EPC PPR-19-054 (RMG Job No. 170915)

December 4, 2020

Re: Frontier Sportsman - Second Submittal  
PPR-19-054  
3385 Pheasant Lane  
Peyton, CO 80831

This letter serves as a detailed letter accompanying the revisions to the Development Plan second submittal set for Frontier Sportsman's Club at the address 3385 Pheasant Lane in the town of Peyton, county of El Paso, state of Colorado. The County review comments are listed as presented in the Memorandum for the Second Submittal dated November 24, 2020. Owner/developer and/or design team responses to said comments are provided below each item. Responses following "MT2" represent comment responses from the general contractor MT2, LLC., responses following "RMG" represent comment responses from the design engineer RMG-Rocky Mountain Group (Richard Lyon, PE). All resubmittal documents and supplemental information requested per the County review comment letter are acknowledged.

SHEET NAME		PROJECT STATUS	
GRADING AND DRAINAGE PLAN 1 OF 2		PERMIT	
ENG:	RDL	DRAWN:	RDL
CHECKED:	RDL	DATE	12/02/2020
#	REVISION	DATE	
JOB NO.	170915		
SHEET NO.	C-02 of 07

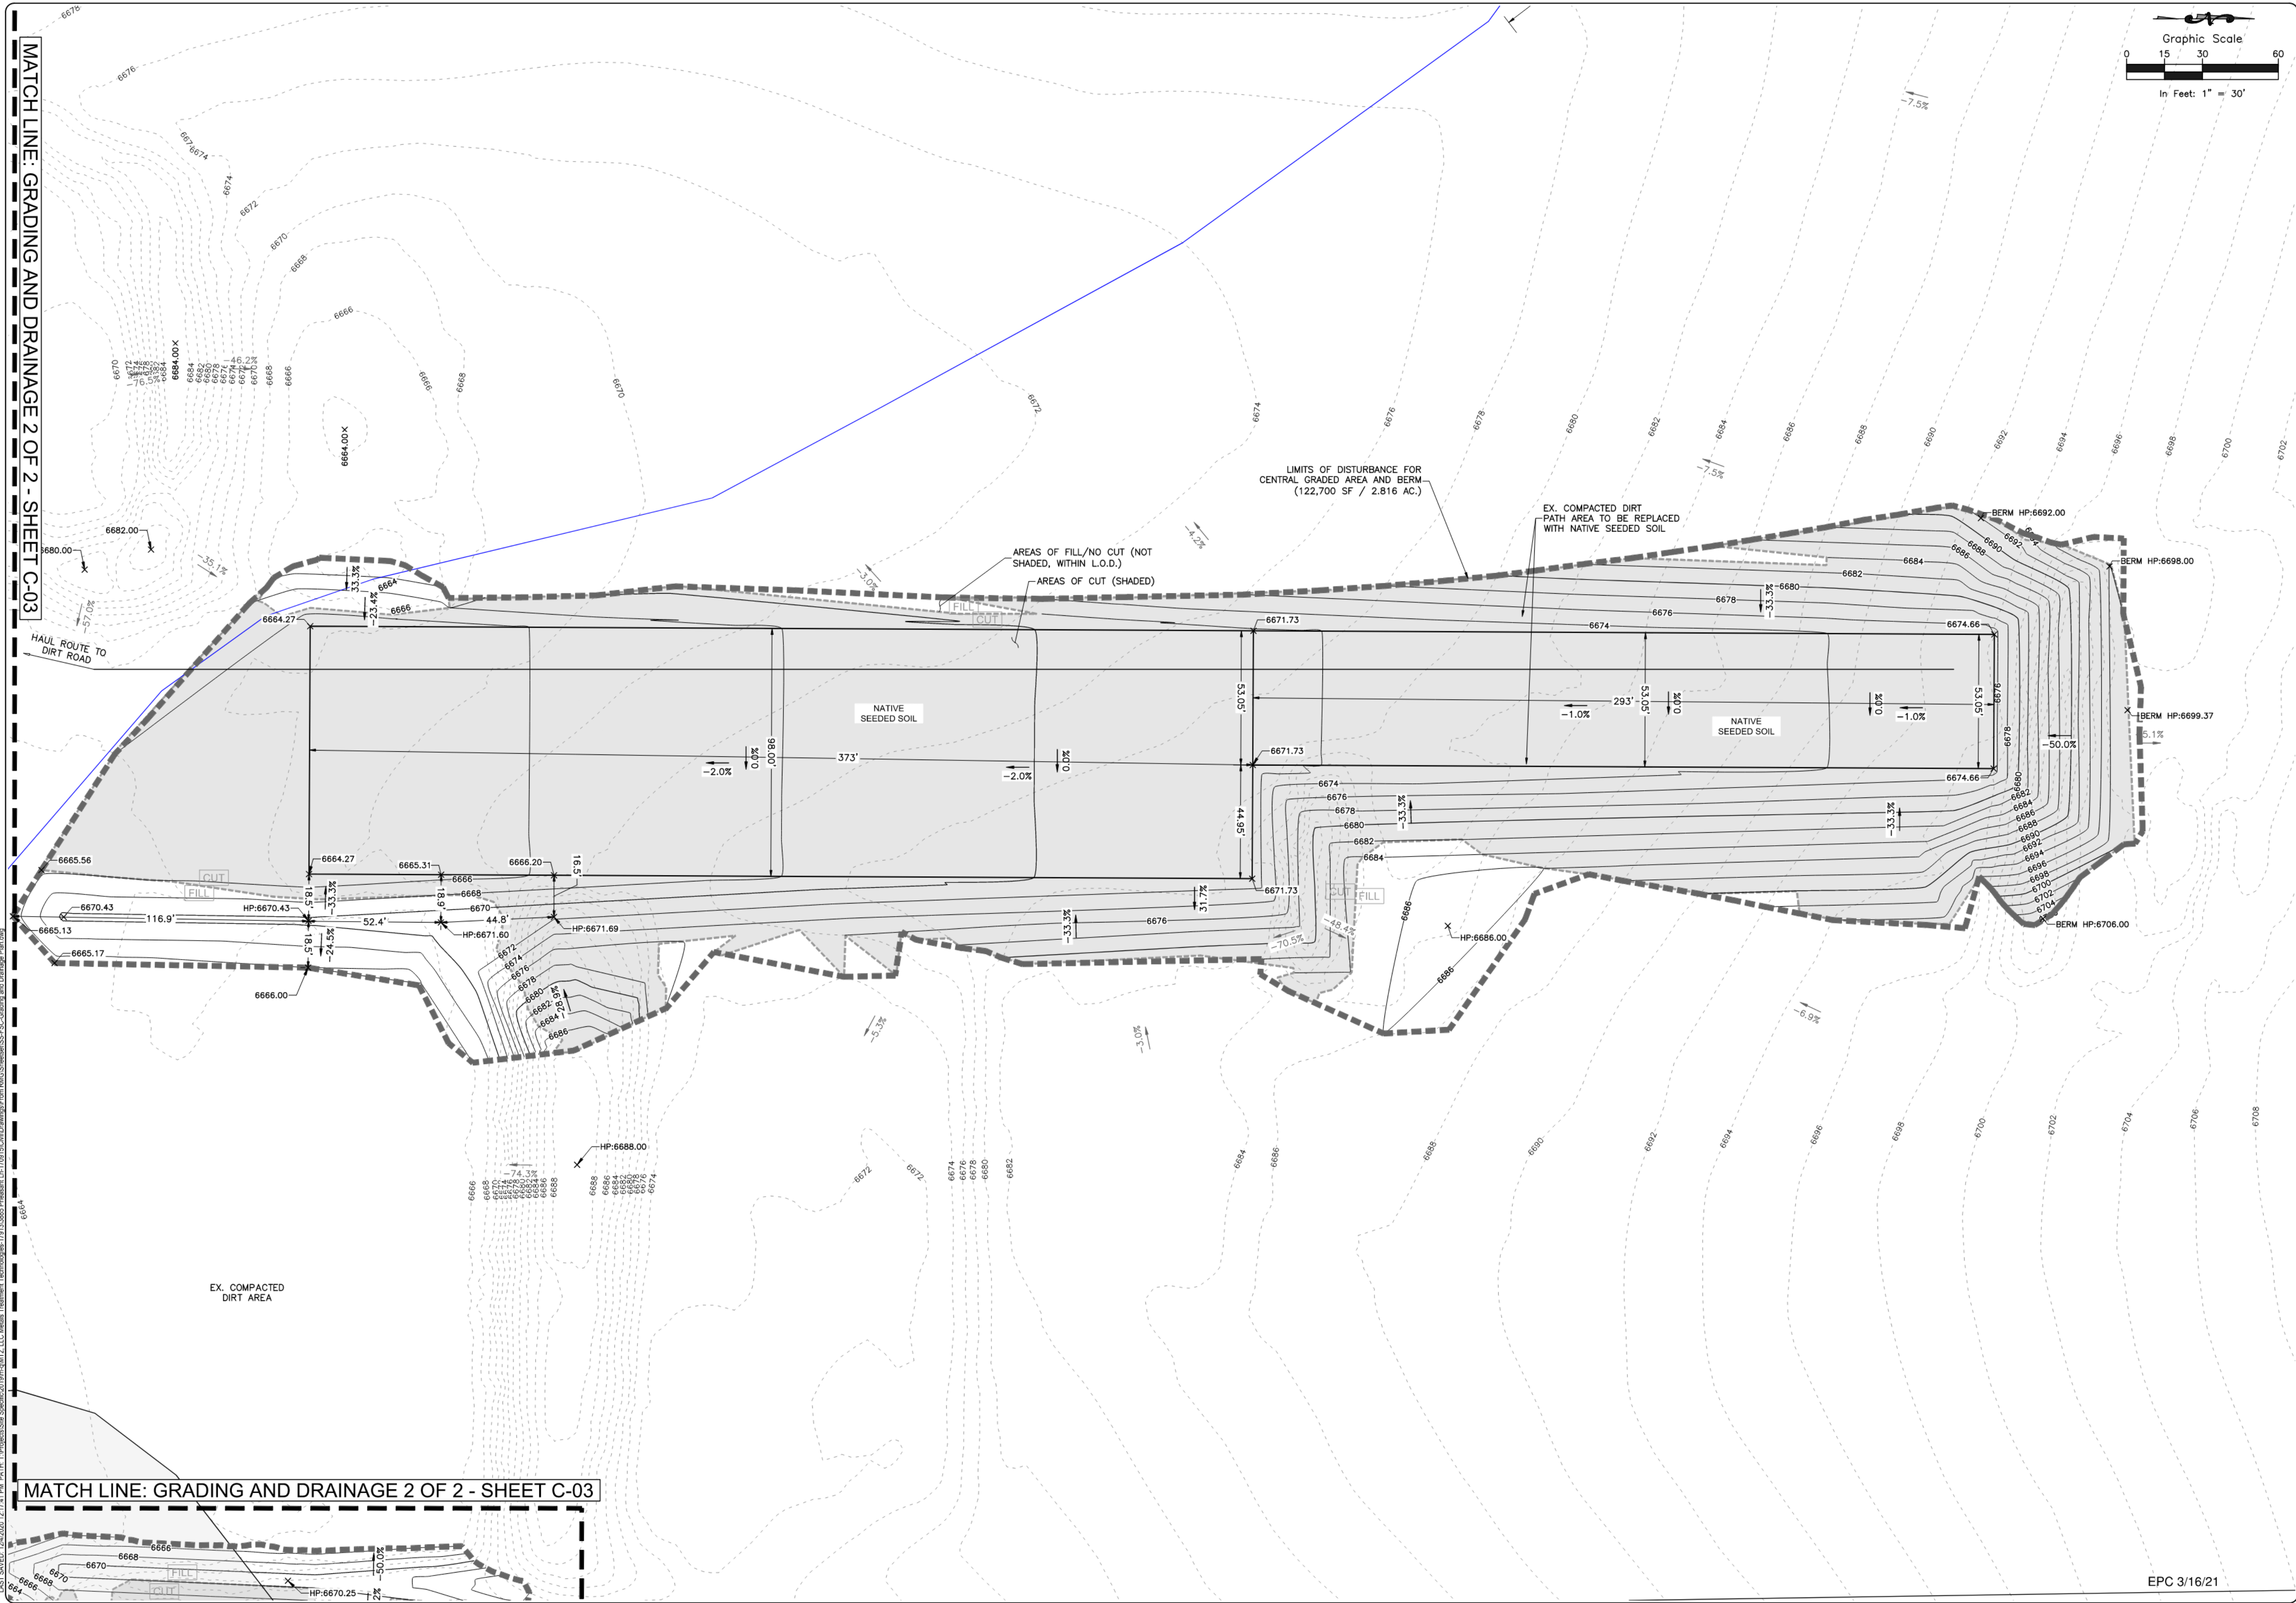
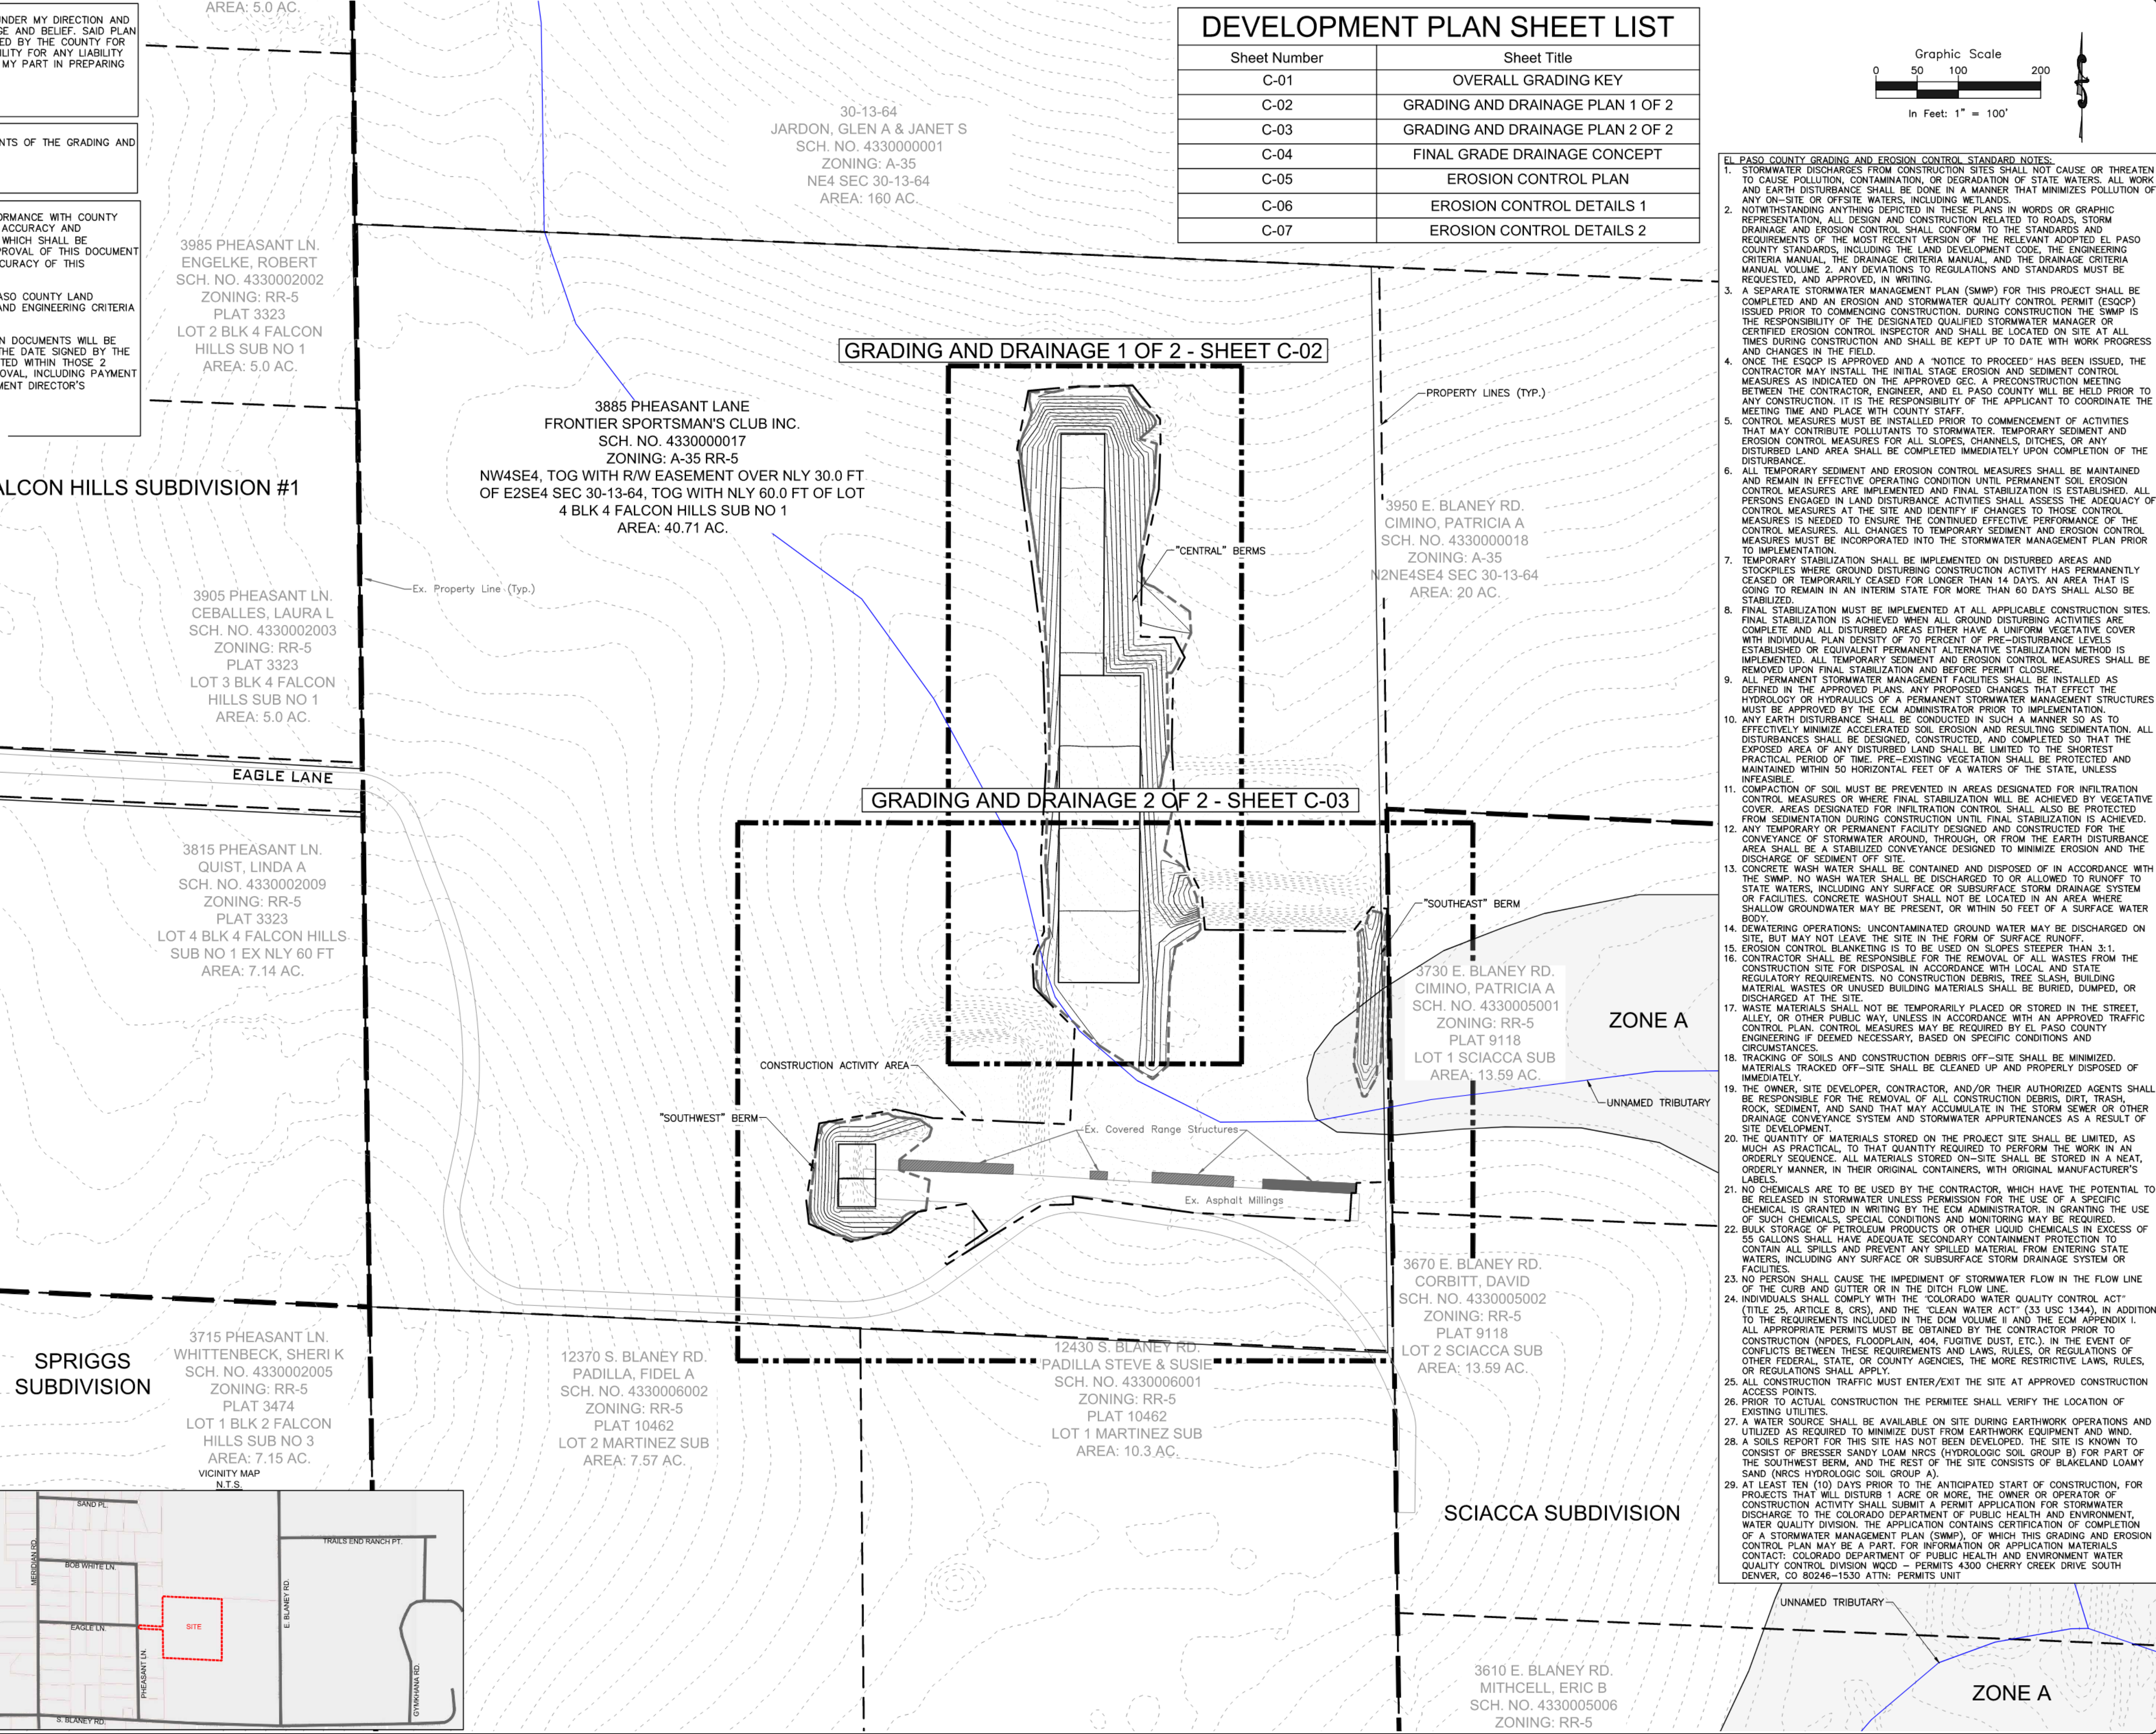
**Regarding checklist item q. comment stating "Need a soils report to know if soils are stable at 2:1 slopes per note on Sheet 1". We have had discussions with County staff regarding the allowance of 2:1 slopes at the backdrop of these**

**shooting range berms. The decision was that permanent erosion control blanket be installed and maintained as a part of the shooting range's operations. As a part of these discussions, we conveyed that it is the industry standard to be closer to 1:1 or 1.5:1 slopes for shooting range backdrops to ensure that ammunition does is effectively caught by the range. It is a safety hazard otherwise. We were under the impression that this item had been settled. Please reach out if this needs to be discussed further.**
